CITY OF ALBUQUERQUE TRANSPORTATION
DEPARTMENT REVIEW COMMENTS
7/11/2016
RBA ARCHITECTURE RESPONSE TO COMMENTS 7/12/2016

TUYET SON BUDDHIST TEMPLE
ARCHITECTURAL - SITE PLAN BLDG. A
ALBUQUERQUE, NM
PROJECT #1580

G TYP. H.C. SIGNAGE
AC2 NOT TO SCALE

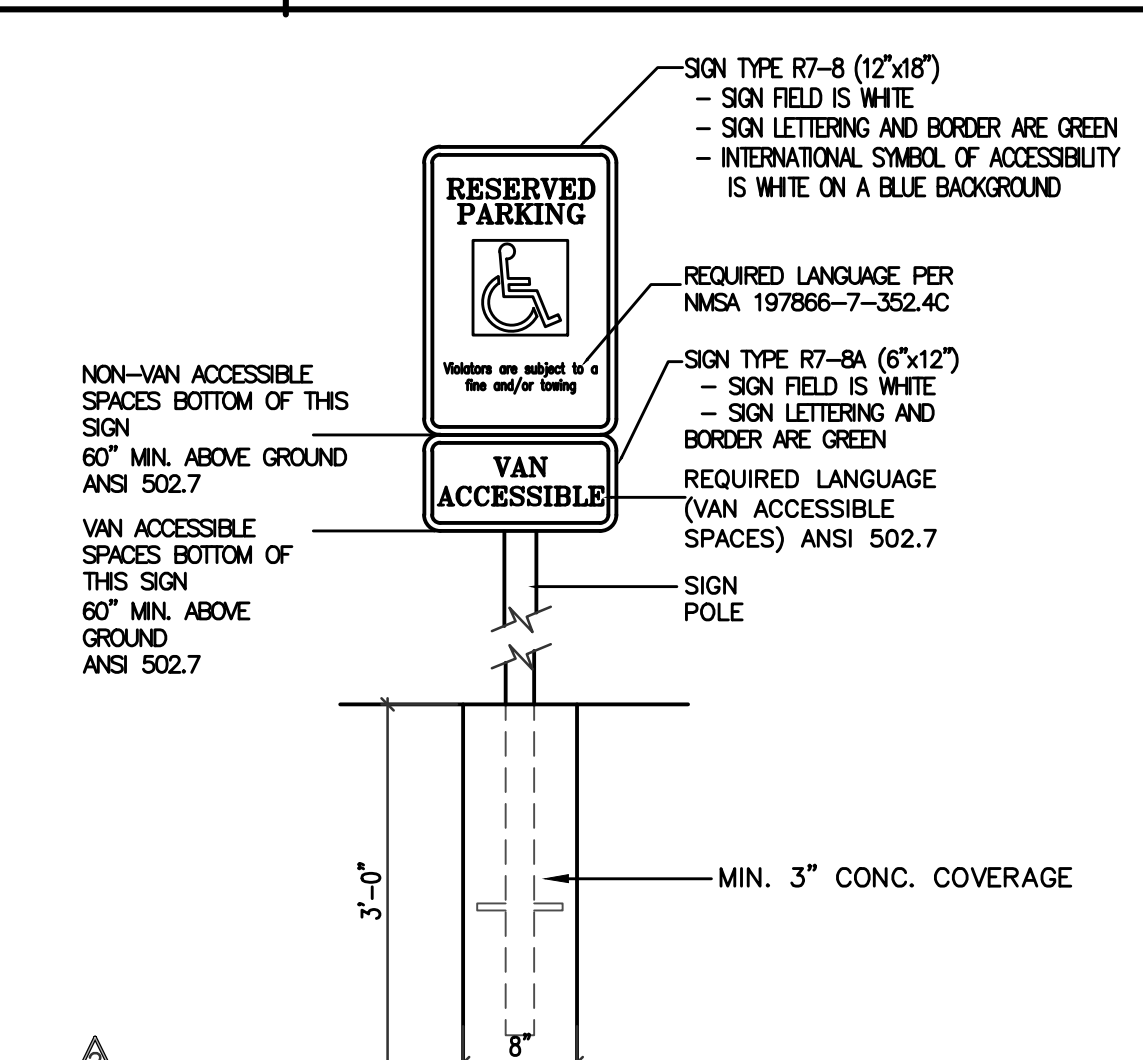
Response: Aisle has been modified to be 8 ft in width.
3. The ADA accessible parking sign must have the required language per 66-7-352.4C NMSA 1978 "Violators Are Subject to a Fine and/or Towing." Please call out detail and location of HC Signs.

Response: Please note that this was called out on our Handicap Parking Signage detail G/AC-2 Site Details Sheet attached to review package.
COA Response: Reference SIGN TYPE R7-8 (12"x18") see detail and attached 2009 New Mexico Accessible Parking Checklist page 3 of 6 "Parking Lot Sign".

TCL-1

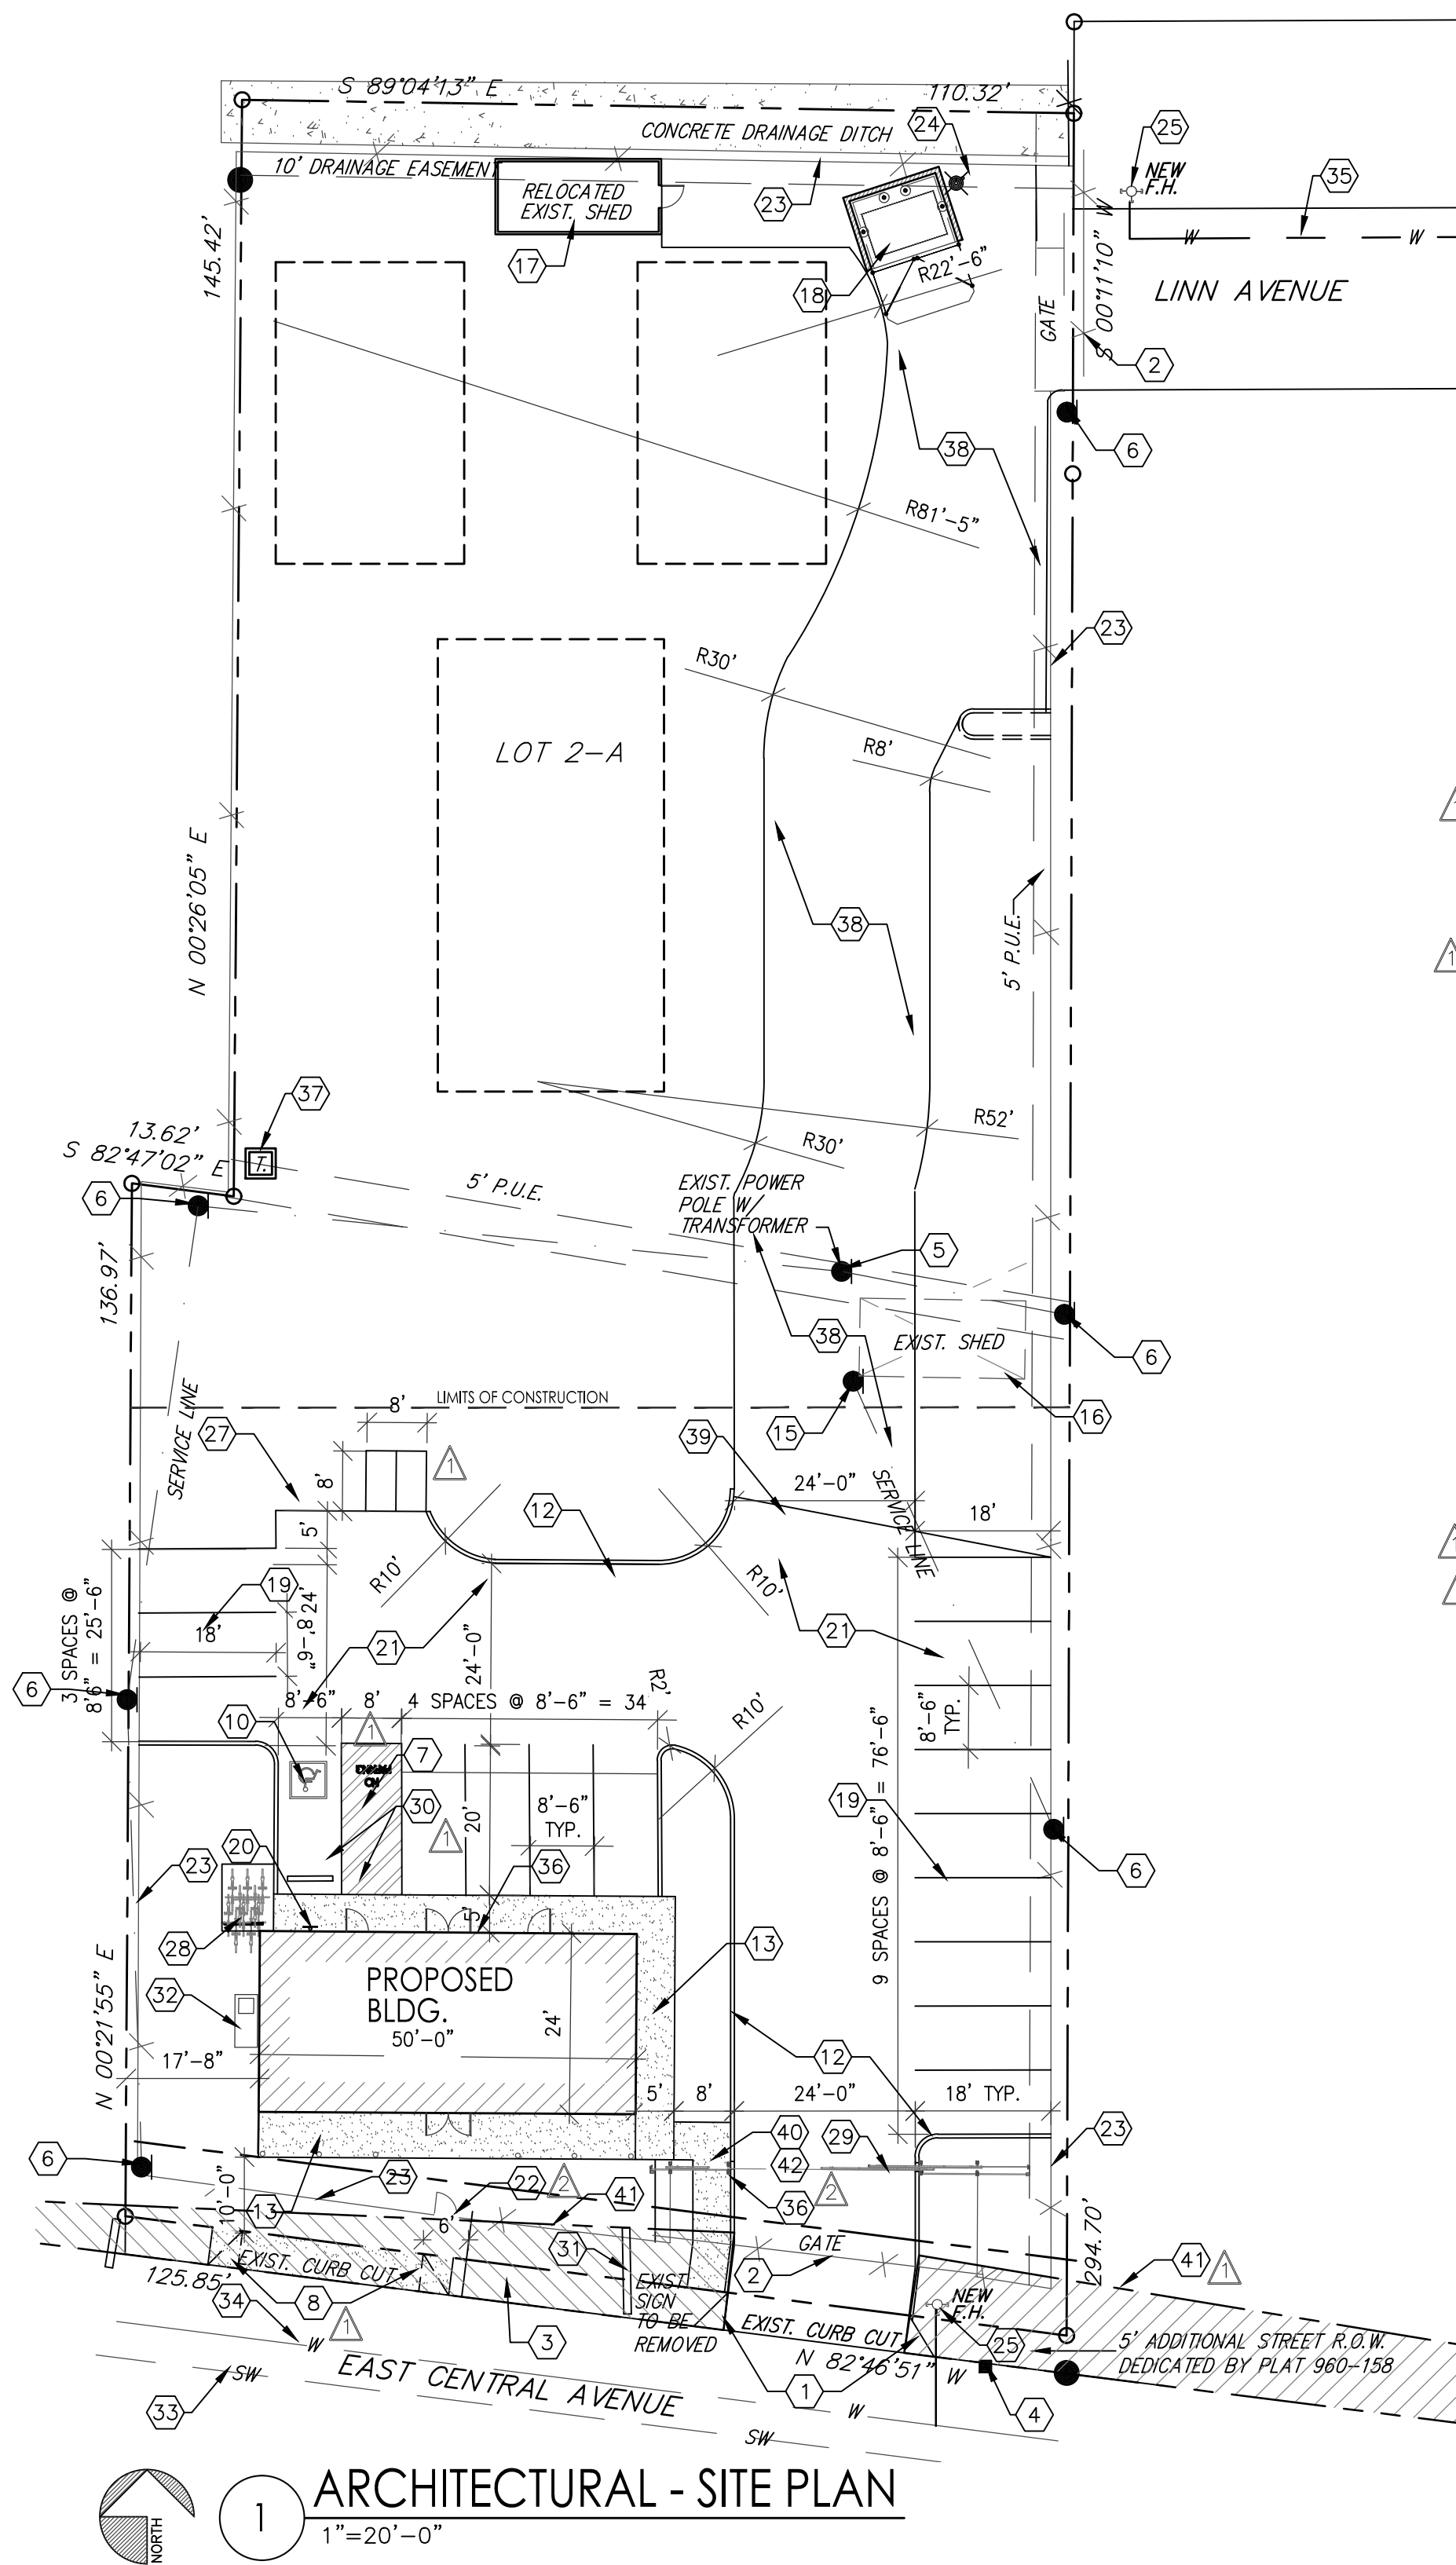
1. The handicap accessible spaces must be a minimum of 20 ft. in length.
Response: Has been modified to 20' length.
2. The handicap accessible spaces must include an 8 ft. access aisle; all other aisles should be 5 ft. in width.

4. We recommend that the motorcycle parking be moved to the East end of the 5 foot key way.
COA Response: Add with motorcycle signage to keyed note 27.
Response: Motorcycle parking spaces have been relocated as directed.

5. Per DPM, a 6 ft wide ADA accessible pedestrian pathway is required from the public sidewalk to the building entrances. Please provide details.
Response: A standard 4" thick 6' wide concrete sidewalk has been provided from the back side of the sidewalk located on Central up to the concrete building sidewalk as indicated on drawing per COA 2430 Paving Sidewalk Details.

8. Please add the following note to the clear sight triangle: "Landscaping and signage will not interfere with clear sight requirements. Therefore, signs, walls, trees, and shrubbery between 3 and 8 feet tall (as measured from the gutter pan) will not be acceptable in this area.

11. Unused curb cuts must be replaced with sidewalk and curb & gutter. A build note must be provided referring to the appropriate City Standard drawing.

Response: Note has been added as key note 8 referencing COA 2415A, 2430.
COA Response: key not 8 does not reference COA STD DWG 2430. Please correct.
12. All broken or cracked sidewalk must be replaced with sidewalk and curb & gutter. A build note must be provided referring to the appropriate City Standard drawing.

Response: Note has been added to sheet as General Notes, note A.
13. Keyed notes 22 and 26 appear not to be called out in plan.
Response: Notes have been deleted.

1. Keyed notes 3 & 40 are missing from plan, please add.
 2. Provide a Knox Box to the sliding entry gates or approval from the Fire Department.
 3. The pedestrian access gate must remain unlocked during business hours. Add note to plan.

Response: Note has been added to drawings, key note 41.
9. Please specify the City Standard Drawing Number when applicable
Response: Will be noted as required.

10. Please add a note on the plan stating "All improvements located in the Right of Way must be constructed through the COA DRC work order process.
Response: Note has been added to drawing as General Note B.
